Our Ref: LU/1/14/TC

**Town & Country Planning Act 1990 (as amended) s211 Notice
Application for Prior Notification of Work to Tree(s) in a Conservation Area**

Development Various tree works within the East Street Littlehampton Conservation Area
Location Franciscan Missionary Sisters St. Josephs Convent East Street Littlehampton

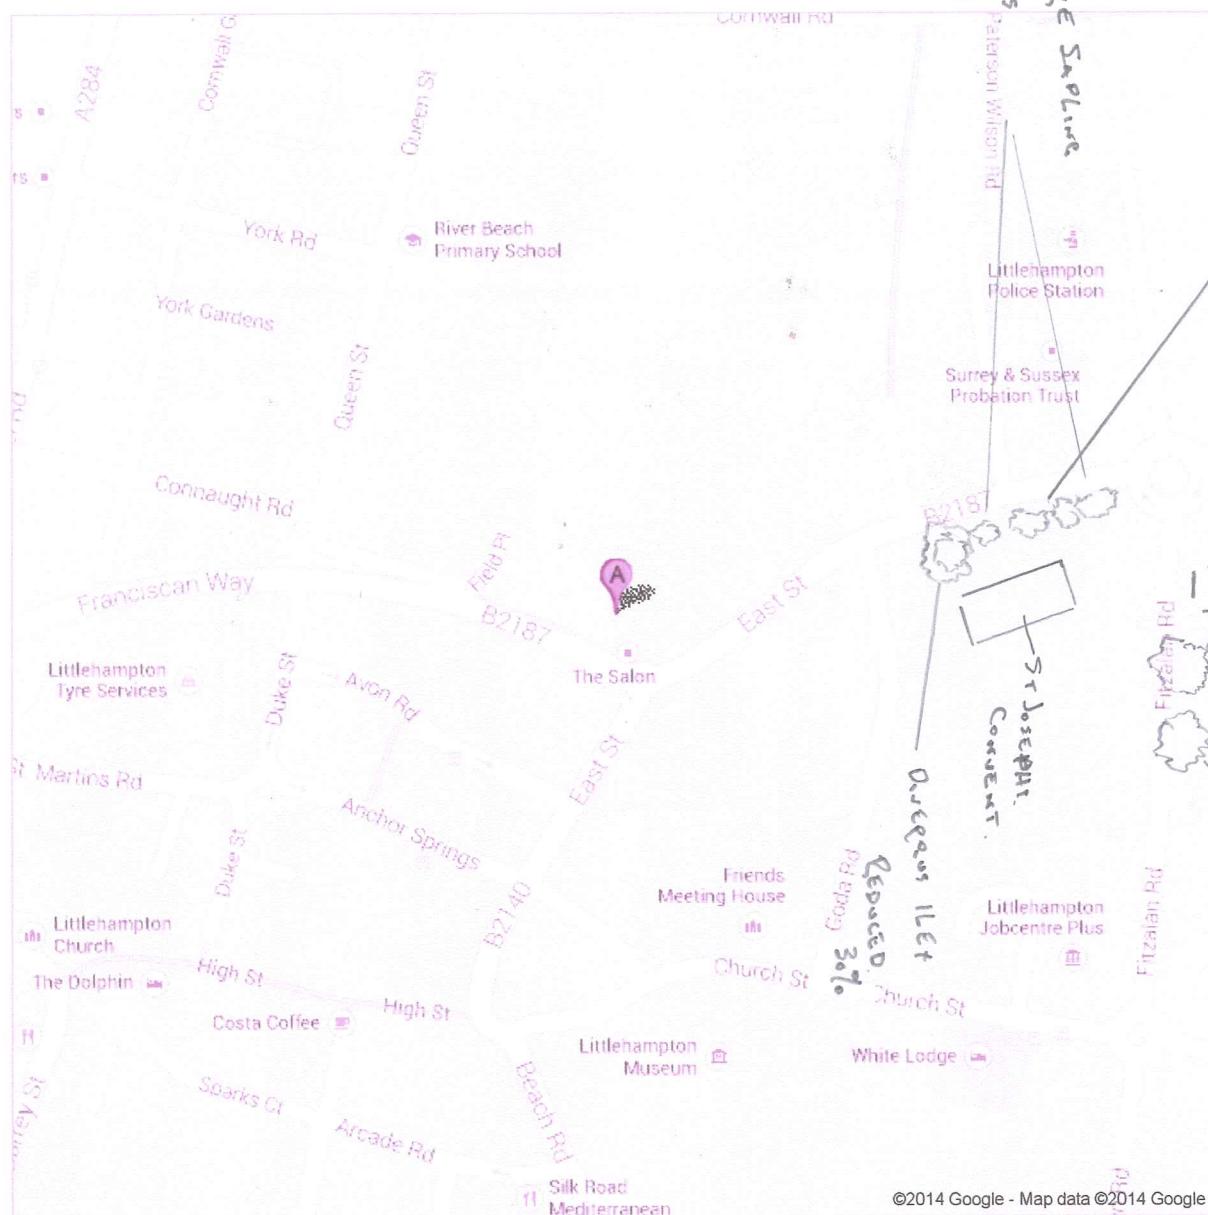
Please provide exact measurements of all proposed works & please confirm how many trees form part of this application. In the description you include numerous trees however the drawing you have provided only indicates 1No. Holm & 1No Bay tree, please amend accordingly.
